RFI

RFI #: 63  
 Date: 2/22/2012  
 Job: EB-02 Keller Springs Lofts  
 Phone: 877-777-5115

Subject: Door Details Clarification  
 Drawing: 3.1D, 3.4D  
 Cost Impact: None  
 Spec Section:  
 Schedule Impact: None

SHEET NUMBER
3.1C
BLDG PLAN 'C'

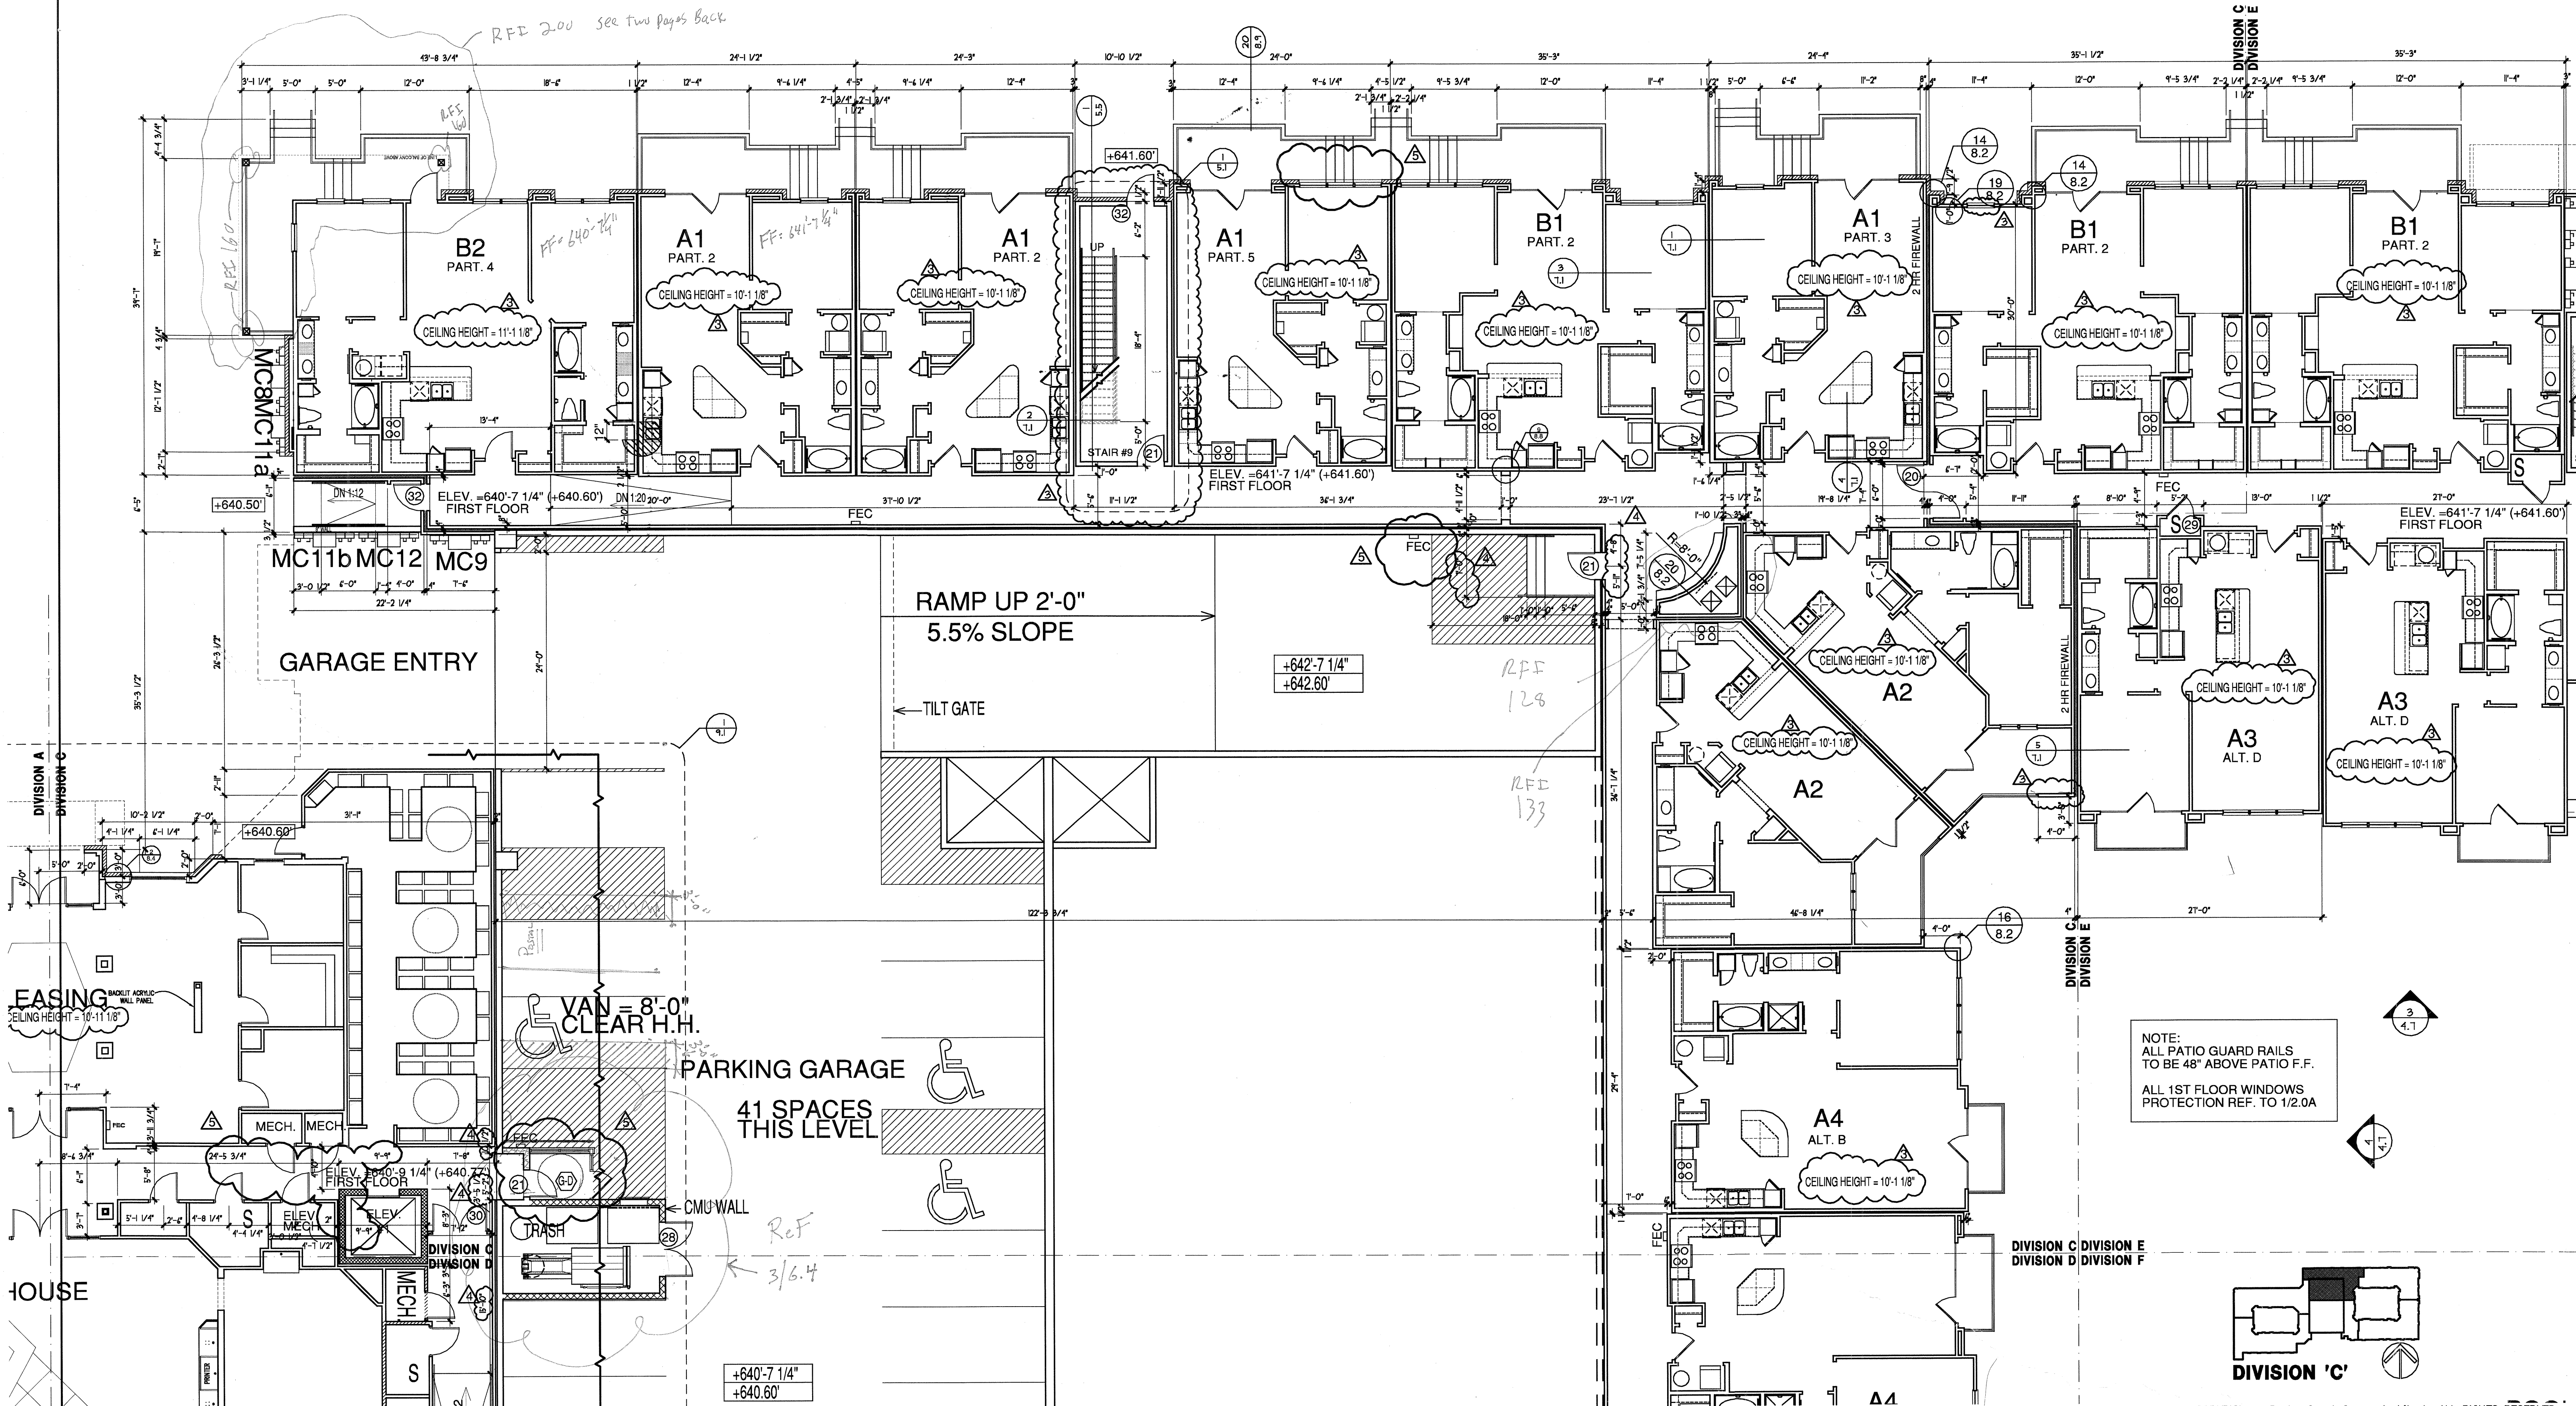
**Request:**  
 Sheet 3.1D shows elevation= 641'-1 1/4" at the corridor of the building on the eastside of garage near A4 at G. unit and ramp. Shouldn't the elevation be 641'-7 1/4" ?

**Response:**  
 Correct 641'-7 1/4" as this part of the corridor on sheet 3.1C

DATE	08-05-2011	SHEET NUMBER	3.1
PROJECT	11129

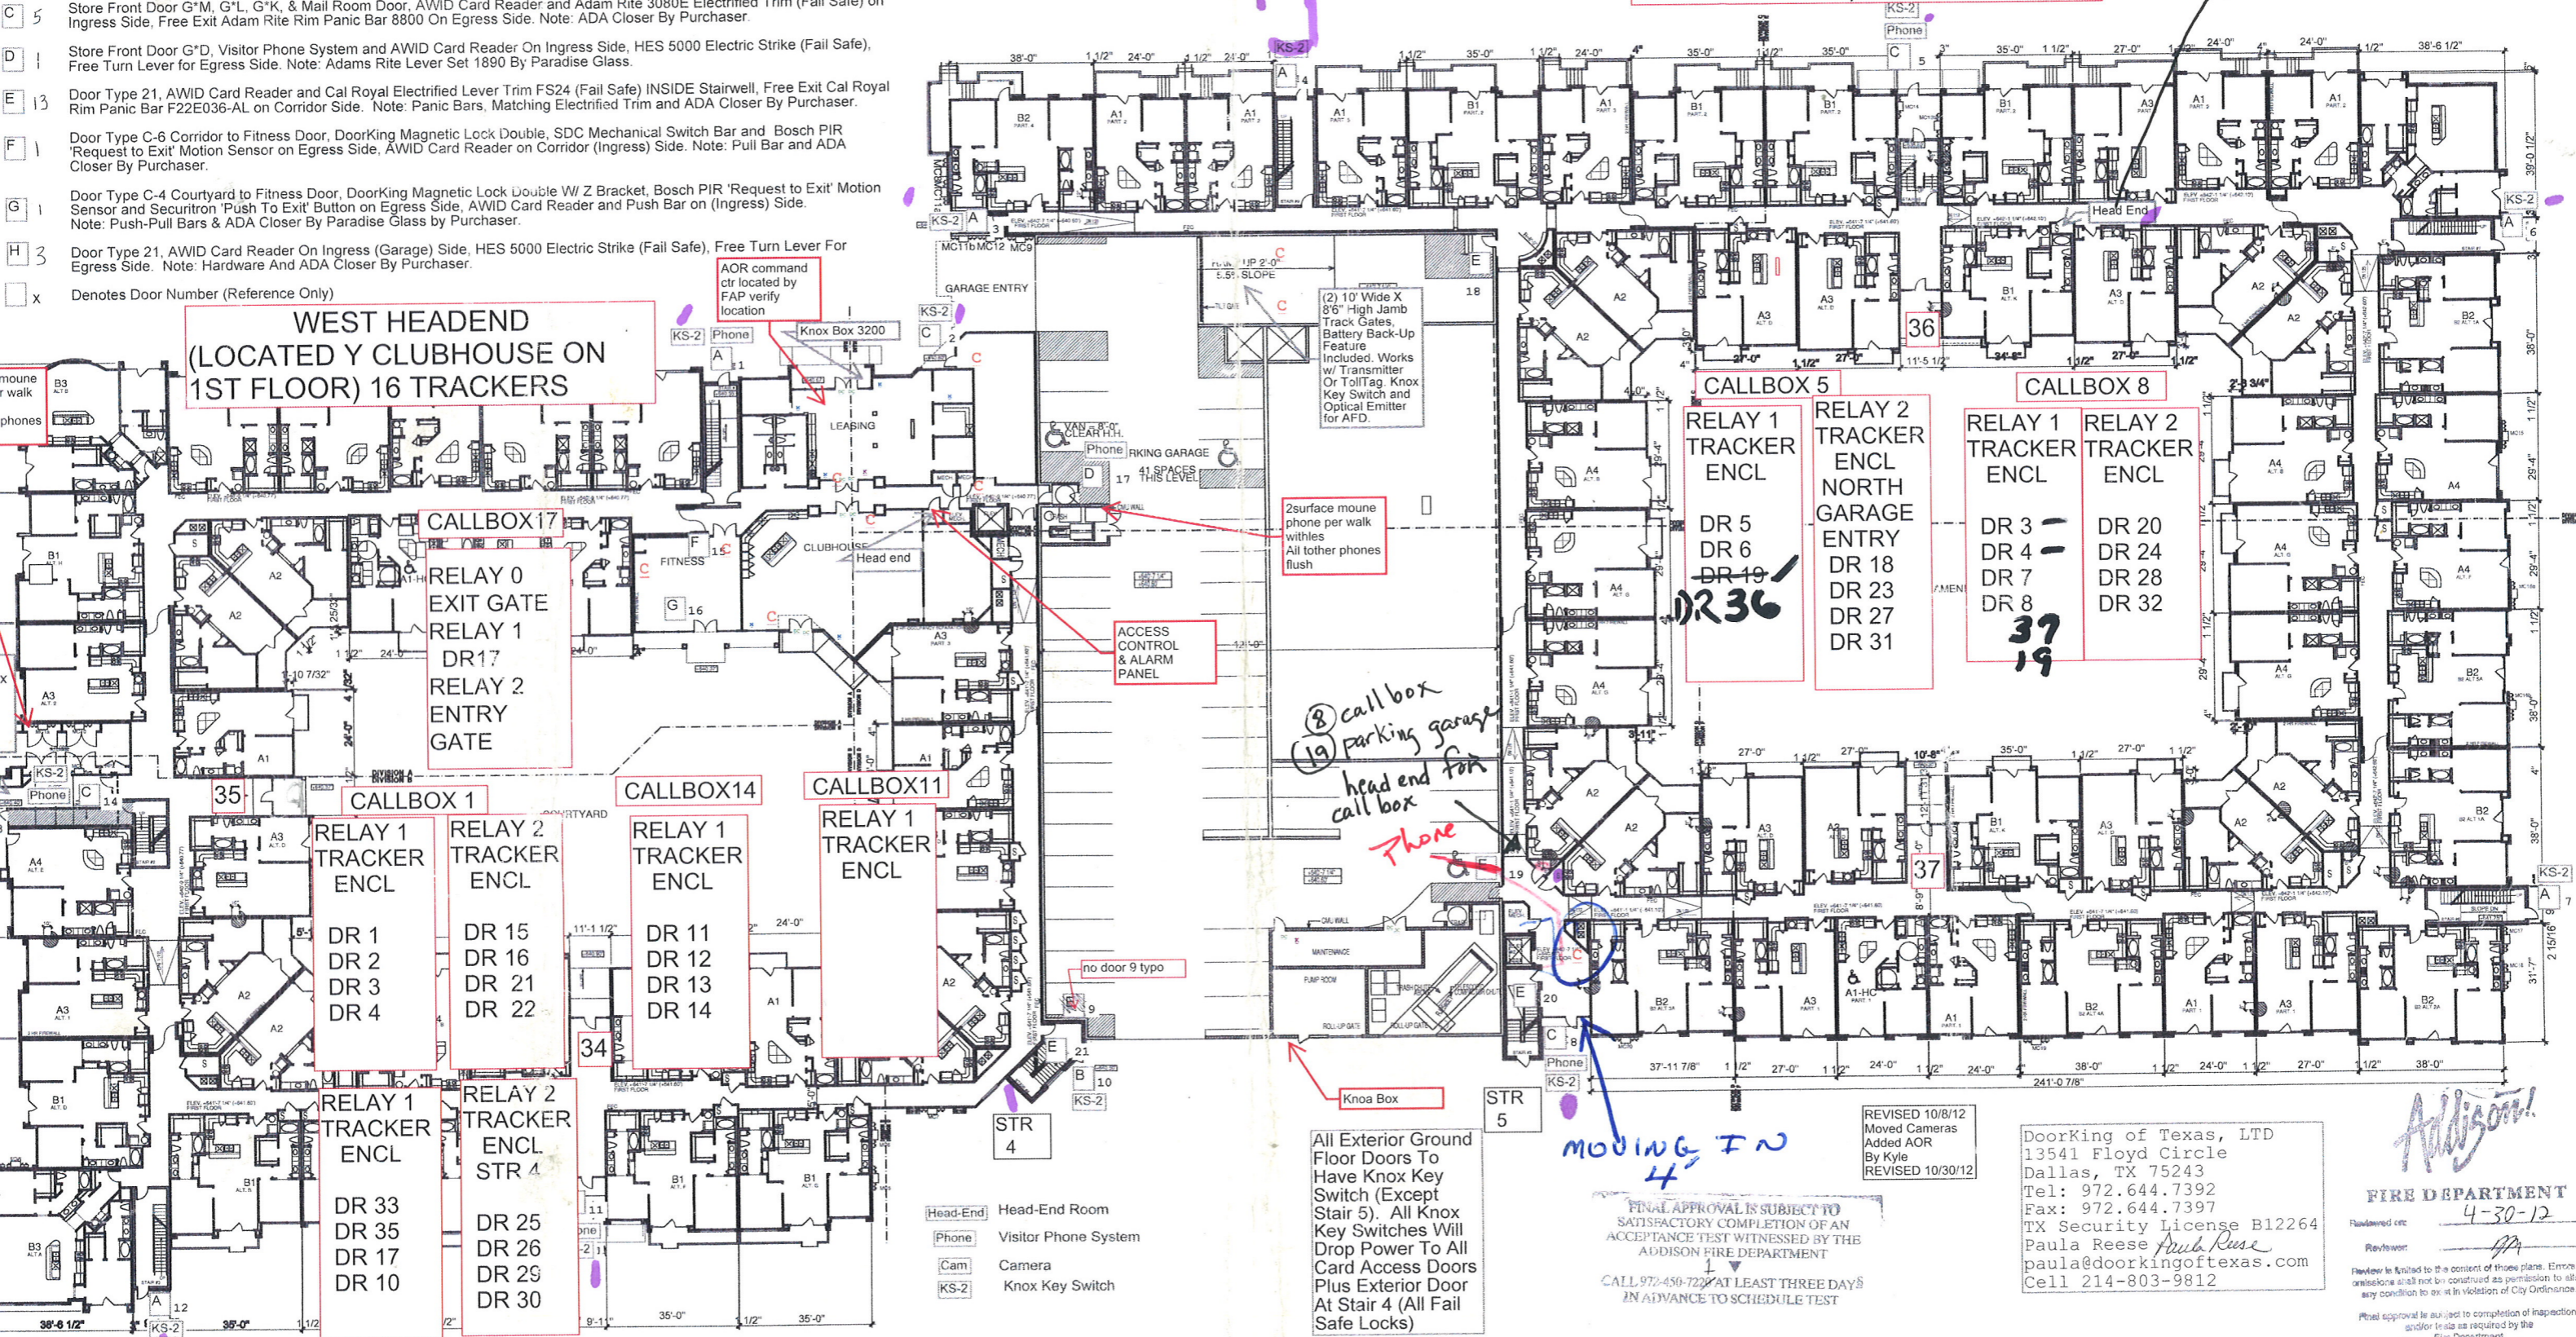
**Request:**  
 1) Arch 3.1 D - Should door mark 32 in stair tower 5 be a door mark 21 similar to stair tower 4?  
 2) Arch 3.4 D - Should double egress door adjacent to A4 units be door mark 20 and not a 21?  
 3) General - Do storage closets adjacent to units need the 1/2" S/R continued in to the closet? Does the 1/2" s/r in units just apply to the units for sound rating?

**Response:**  
 1- No.  
 Stair 4 should have exterior door 32 like Stair 5  
 2- Correct.  
 3- The sound rating only applies to the units.  
 see next pages for more info.
